Kittitas County Community Development Services
411 N Ruby Street, Suite 2
Ellensburg, WA 98926

I am writing this letter in response to the application for Large Plat submitted by Thorp Landing (LP 23-00001) and the environmental impacts this proposal will have on the current land, adjacent lands, and the community.

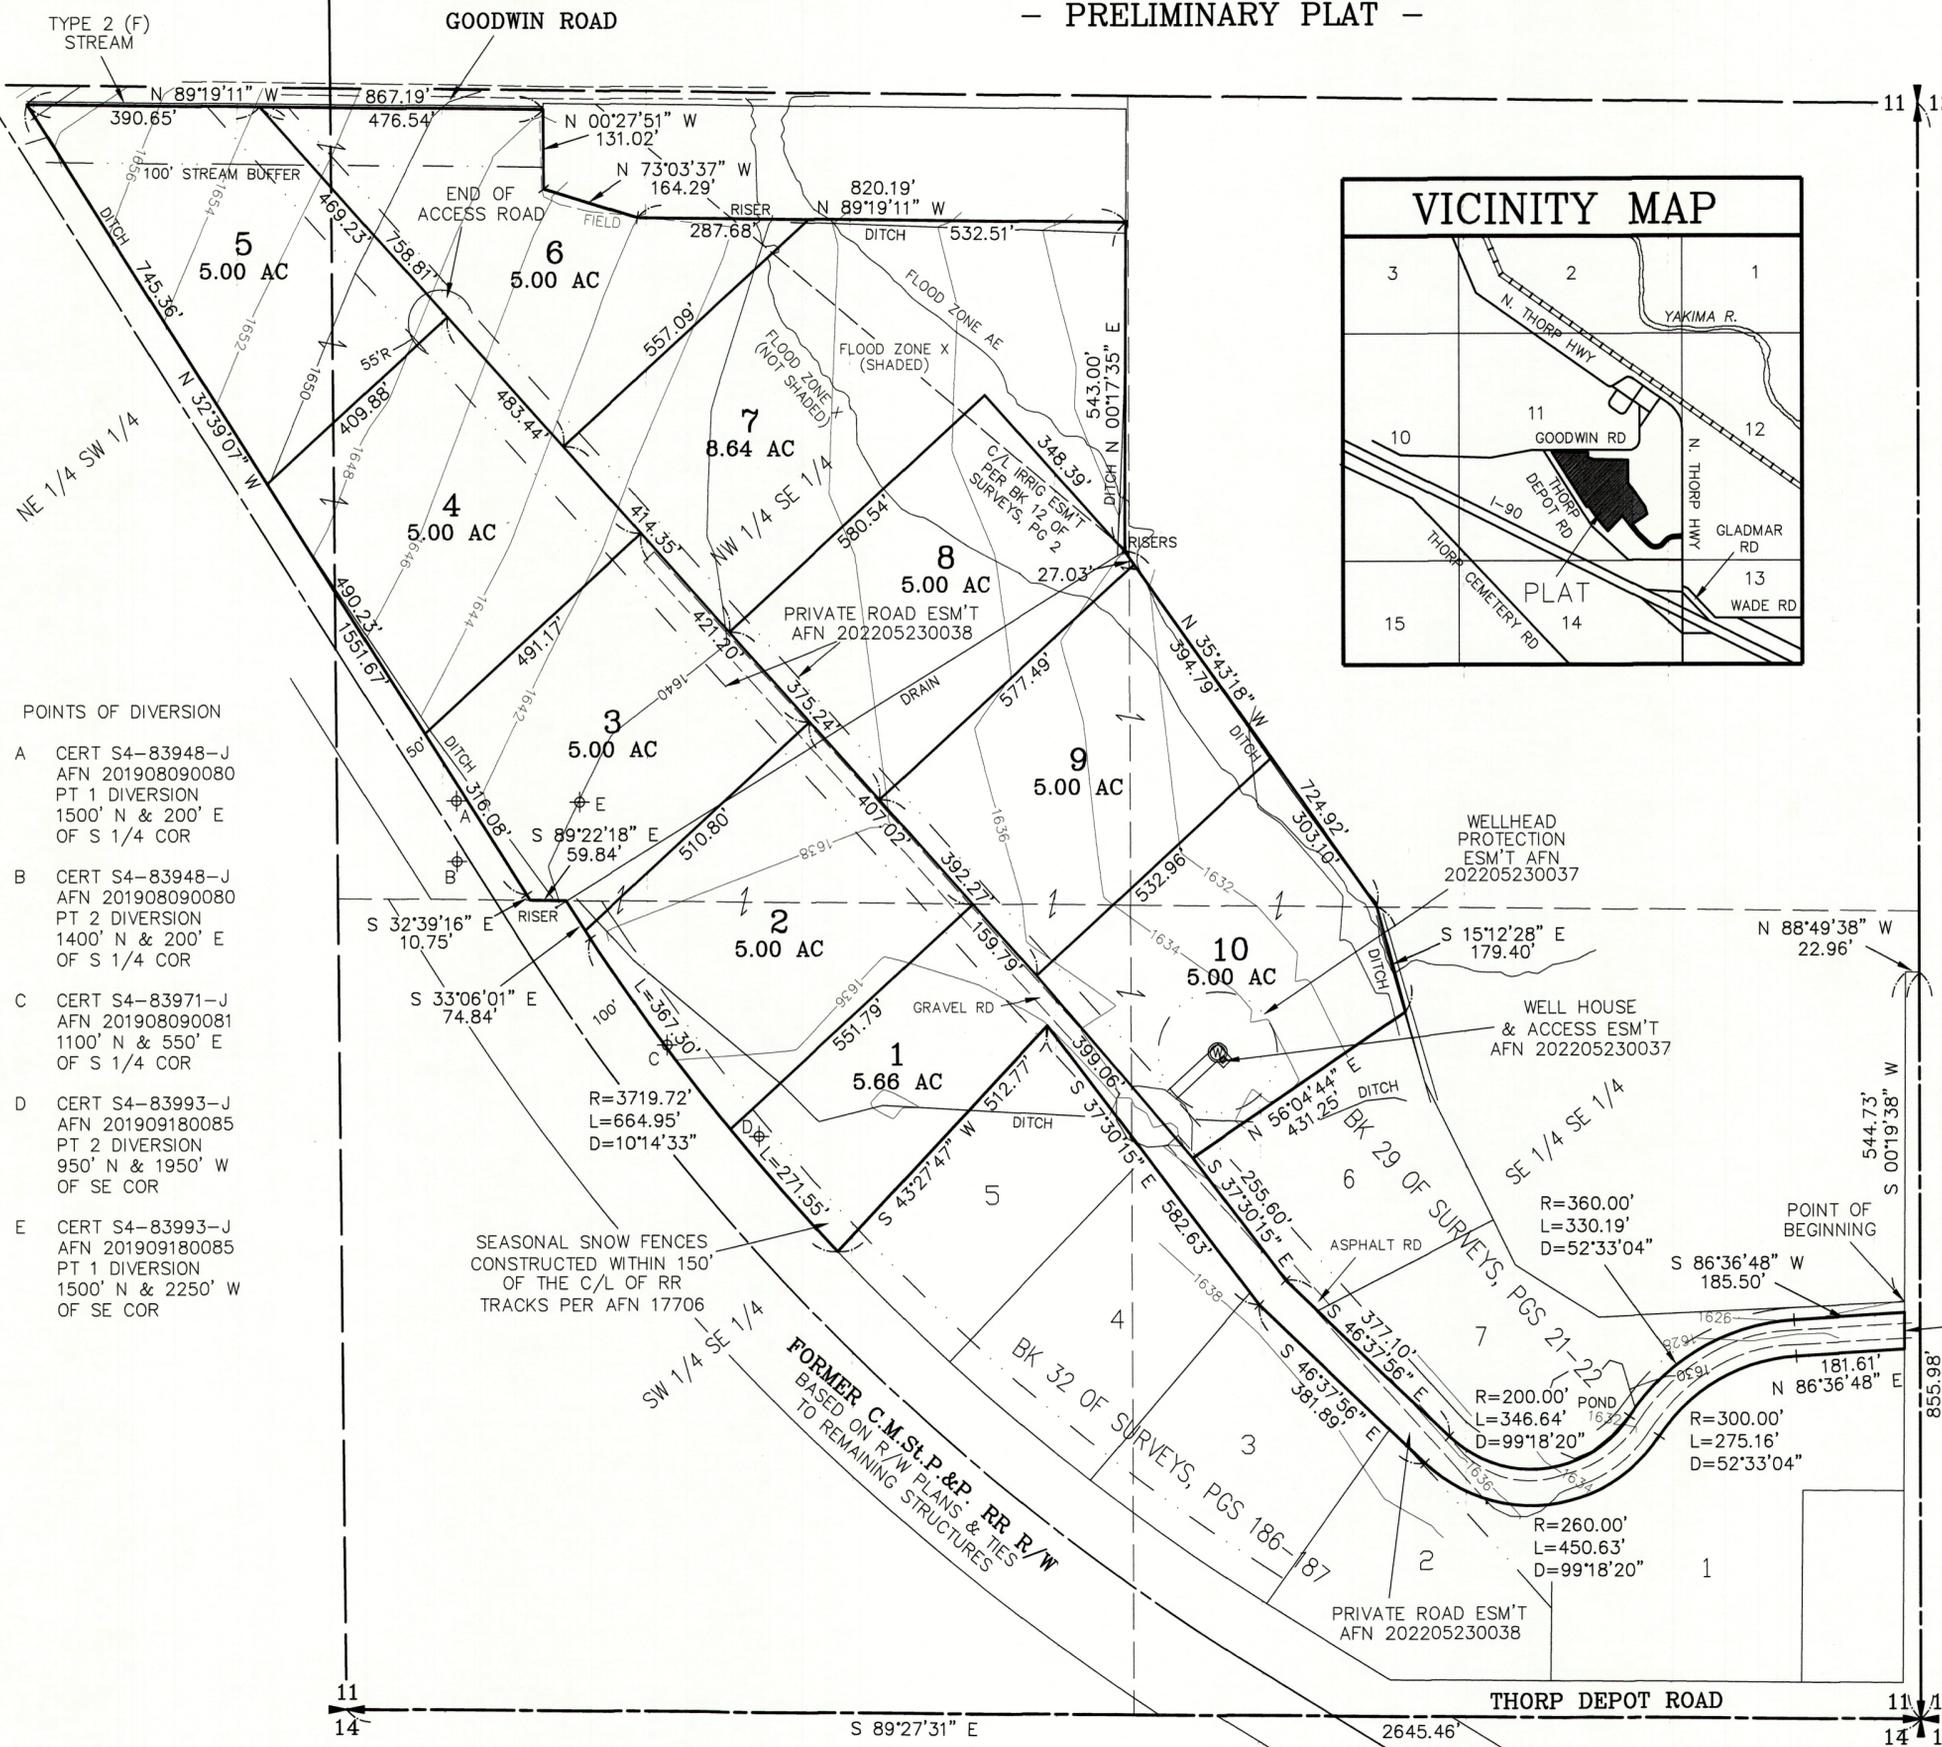
In addition, drainages and easements are clearly identified on the preliminary plat map updated 1-25-23 that was submitted by Thorp Landing. The drainage which corresponds with perennial spring B on exhibit A, and the Fudacz irrigation easement, also outlined in exhibit A, cannot be altered as outlined in RCW 64.04.175. In addition, proper setbacks must be enforced, and current lots do not line up to provide setbacks nor do they provide adequate protection for such easements.
